**63855 – Salesbury
View**

**Highways and
Transport Review**

July 2026

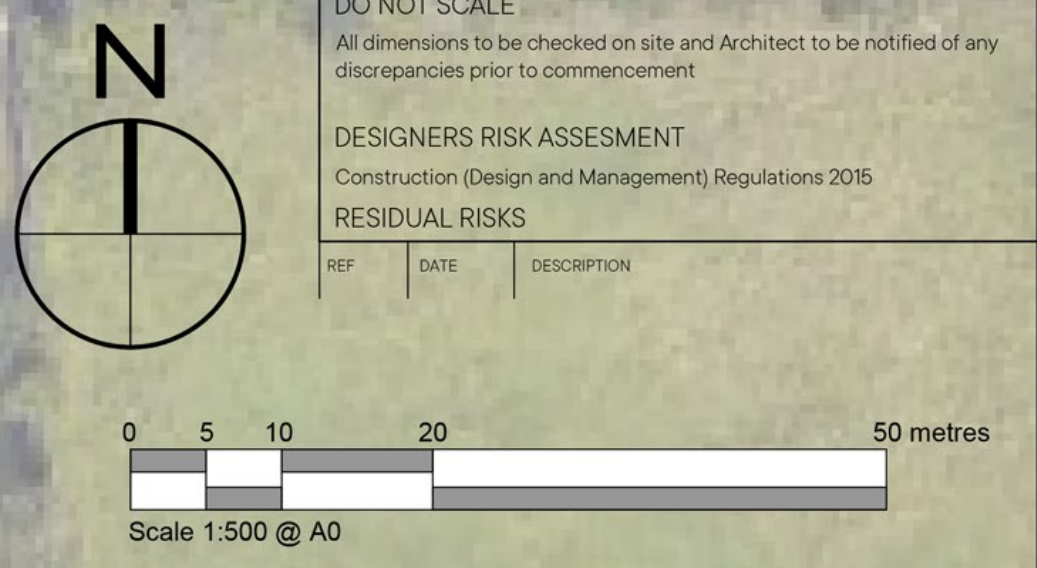
- 1.4 This review therefore considers the issues of concern to the local residents who use the highways in this area on a daily basis.
- 1.5 As will be seen there is one issue which is very serious and we believe would require a major alteration to the design of the scheme to address. This would be described as the site's sustainable transport and / or inclusive mobility characteristics, but in layman's terms would be the effects of the severe gradients of the carriageways and footways that would be involved within the site.

- 1.13 The proposed development would extend Salesbury View with the access road splitting into 3 once within the site. Each of the 3 routes would be culs-de-sac with no alternative emergency access. The longest of the culs-de-sac would be around 390m (measured in a horizontal plane – considerably longer when the actual road length to accommodate the change in levels is considered). In addition to the 70m long 1 in 8 existing section detailed above, much of the length of the new sections would have long lengths with gradients of 1 in 12 (and lengths with an even greater gradient).

- 3.17 From our knowledge of the area, we can safely say that it would not be possible to access this site with the current general arrangement without long lengths of the access roads being at 1 in 12 or steeper, which not only does all the advice says would not only be unacceptable in planning terms, but which would be dangerous to highway users and completely in conflict with the Equalities Act 2020.
